Our ref: RA/2024/147529/02-L01
Your ref: 2024/92236

Date: 14 April 2025

DEMOLITION OF EXISTING INDUSTRIAL BUILDING AND ERECTION OF STORAGE AND DISTRIBUTION BUILDING WITH CAR PARK AND ASSOCIATED ENGINEERING WORKS – WOOD STREET MILLS, WAKEFIELD ROAD, SCISSETT, HUDDERSFIELD, HD8 9JS

Title:  
Proposed Site Plan (Floor Plan)

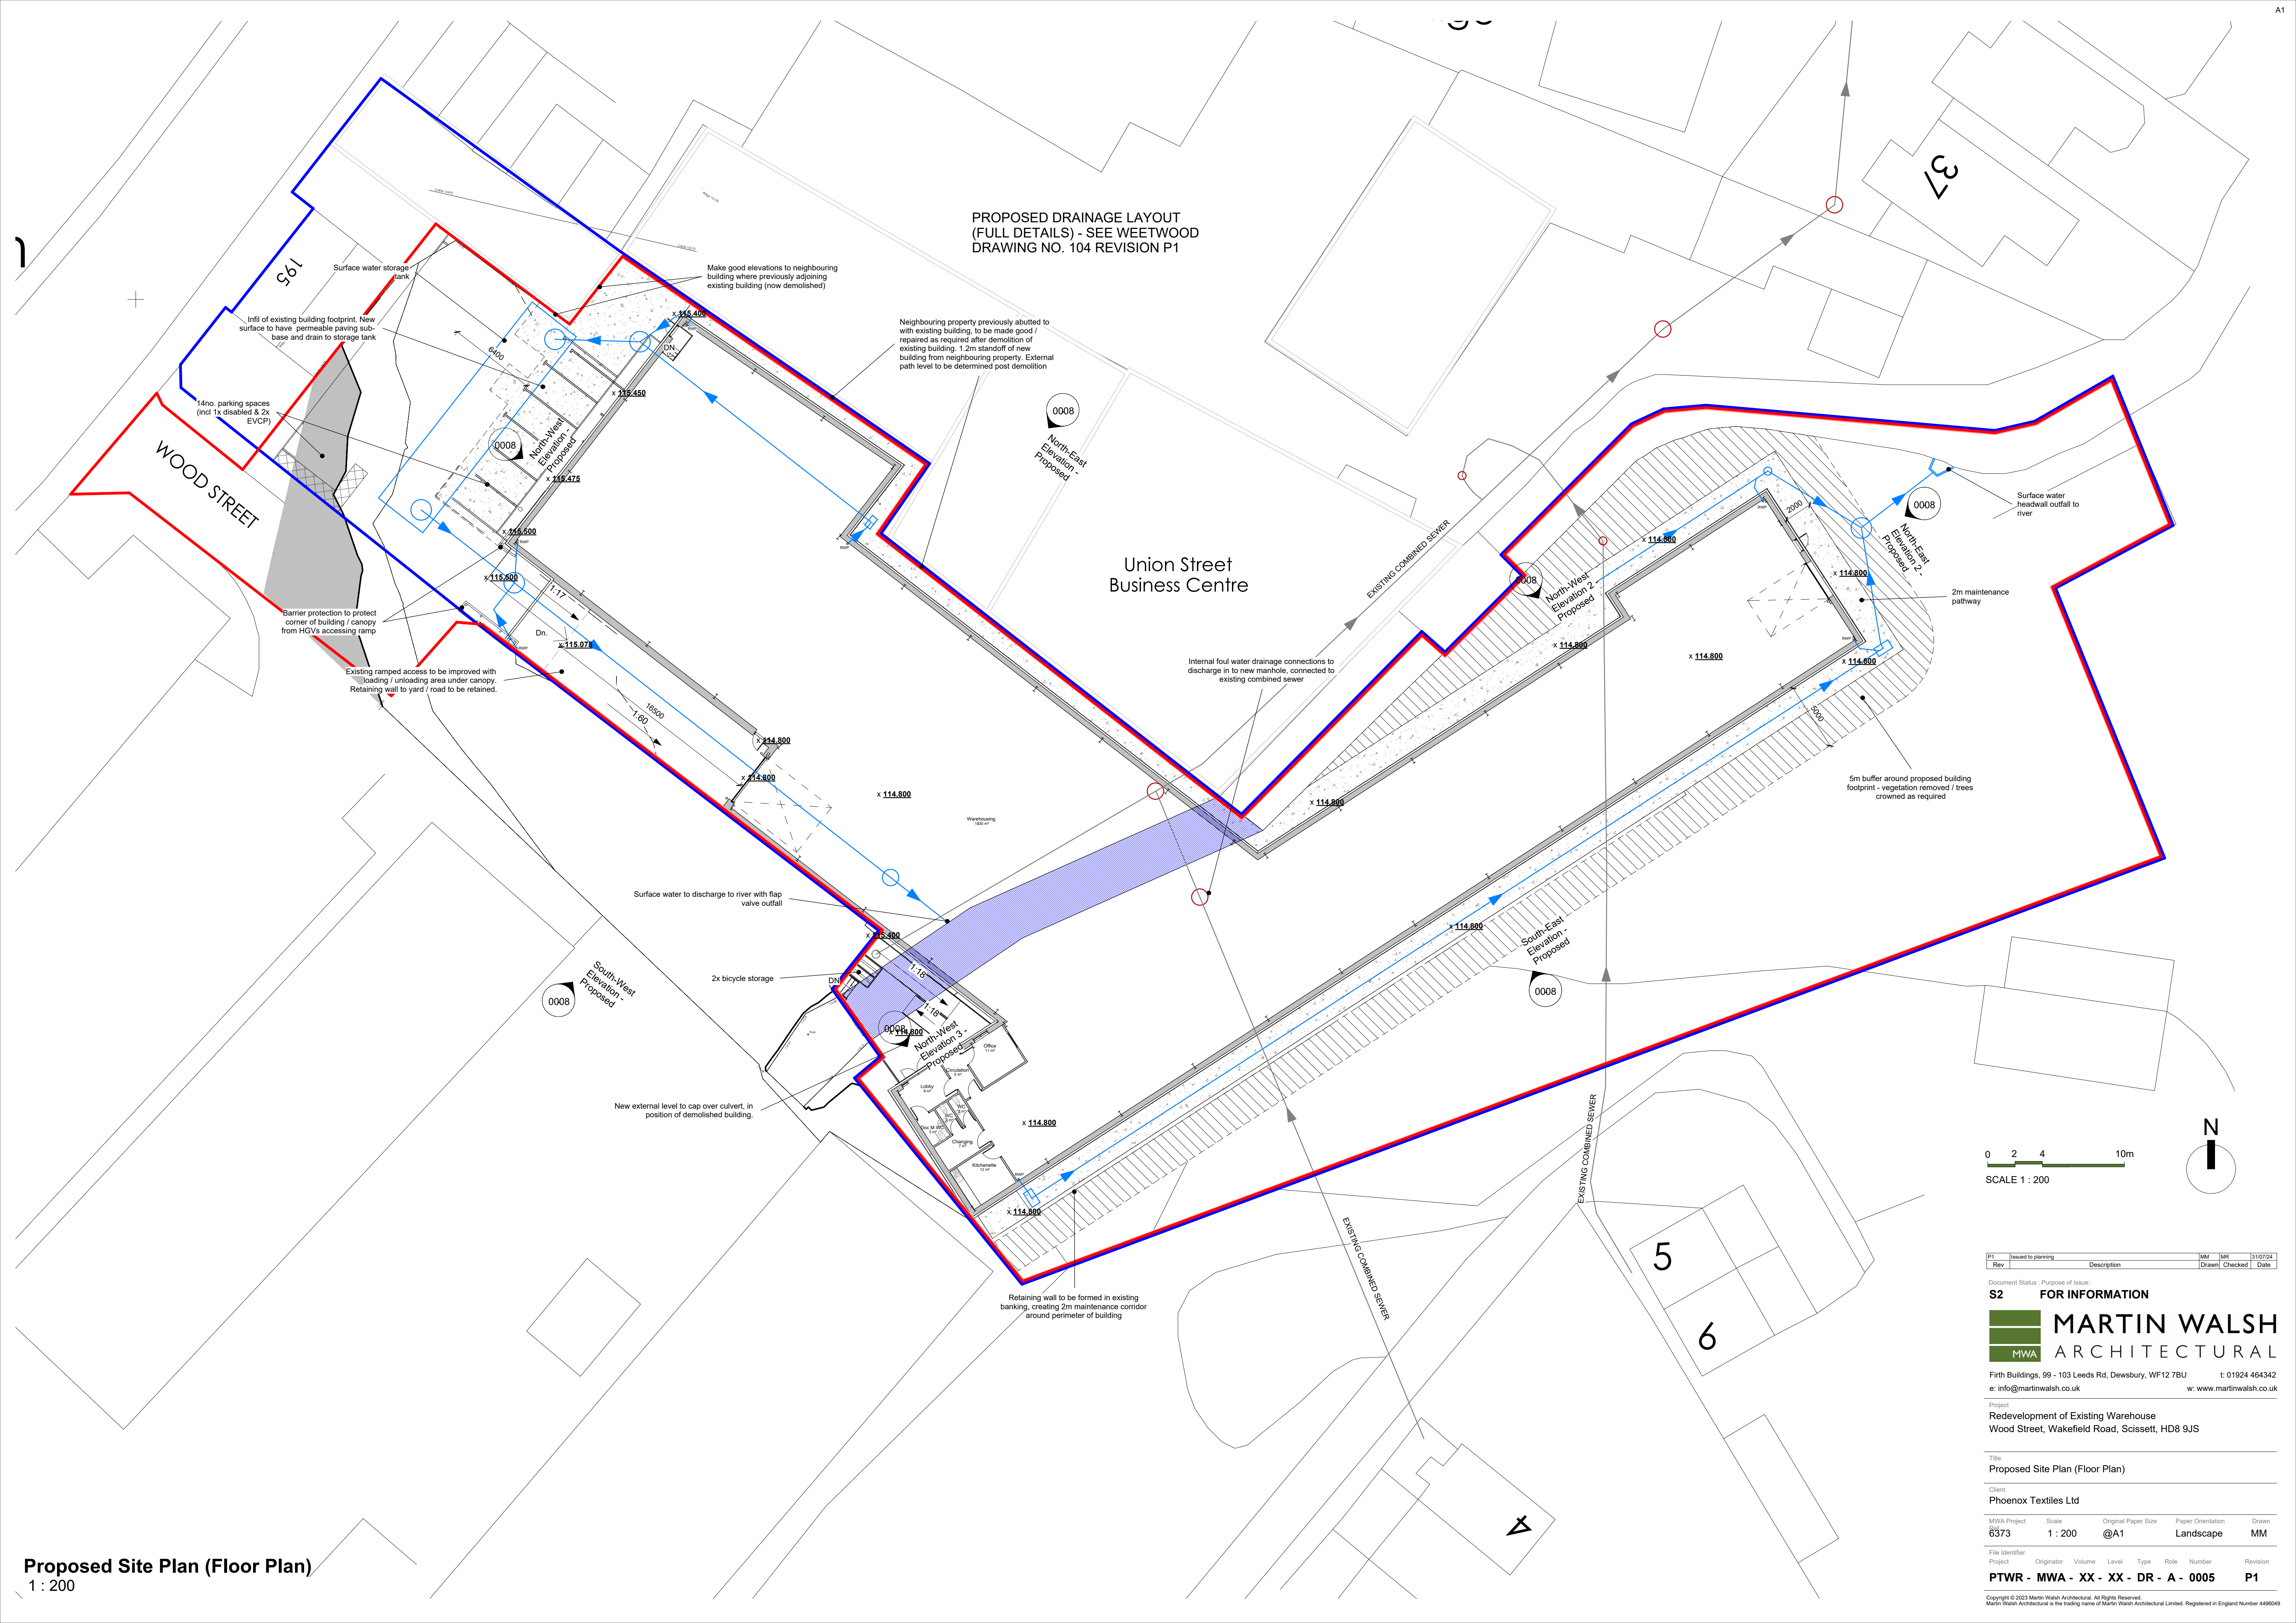
However, Option 3 “*Open up the extreme western part of the culvert, which is not affected by new building footprint (partial deculverting)*” remains feasible.

The applicant states this option “*would require the building to be re-organised – by moving the main pedestrian entrance to the north of the site, where parking is proposed. However, a modest level of deculverting could be achieved.*”

We disagree with the applicant's justification for discounting this option which states:

We recommend the applicant develops Option 3 as this would deliver ‘Policy LP34 Conserving and enhancing the water environment’ of the Kirklees Local plan which states that:

Whilst we recognise that deculverting 6 metres of the Dearne through Option 3 will still leave remaining culverted sections along this reach, it will result in localised improvement to hydro-morphology and river habitat in this constrained section of the watercourse. Therefore, the ecological value that Option 3 would provide should not be overlooked.
